From: William Simcock
Sent: 11 September 2020 08:51
To: DCAdmin
Subject: FW: Consultation response 2020/91337 Mount Pleasant

From: Sharon Huddleston
Sent: 08 September 2020 22:07
To: William Simcock <William.Simcock@kirklees.gov.uk>
Cc: Jamie Turner <Jamie.Turner@kirklees.gov.uk>
Subject: 2020/91337 Mount Pleasant

PROPOSED BLOCK PLAN
1:500

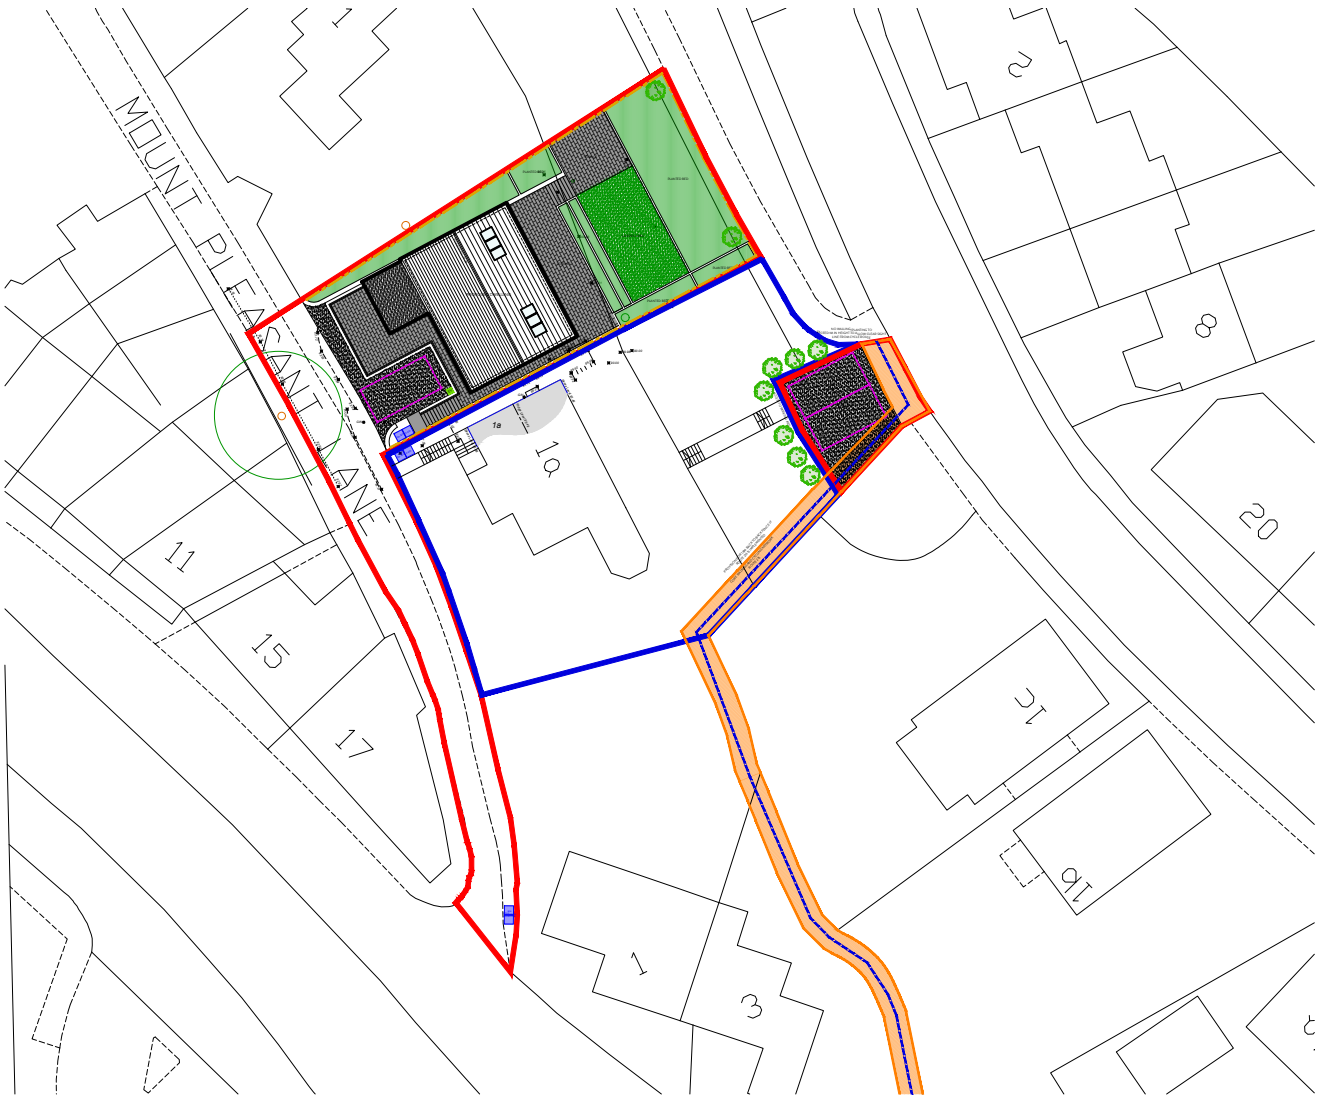
With regards to the parking situation, it appears that the parking is being moved for 1a to access from Fenay Bridge Road. Adjacent to the where the proposed parking spaces will be is a cycle track that appears to be via a section 106 (2001/90629) and a planning application for a 2.5 m wide cycle path (2007/90537). We are unsure from the S106 details of the extent of the land included and any verge/apron that would normally be included.

Prow is concerned regarding this parking :-

- Will it encroach onto the cycle track, can they fit in 2 spaces
- Ensure that the site lines for the parking do not obstruct the cycle track
- The LRR does not show ownership to the adopted highway but the BLB includes the section (no details on the application who they have served notice on)
- The RLB of 91337 does not include the parking spaces
- The RLB of 91337 appears to include land up to the cycle track and outside the ownership with what appear to be a fence/boundary at the rear of the new property. No details of this are included application or what affect this will have on the cycle track
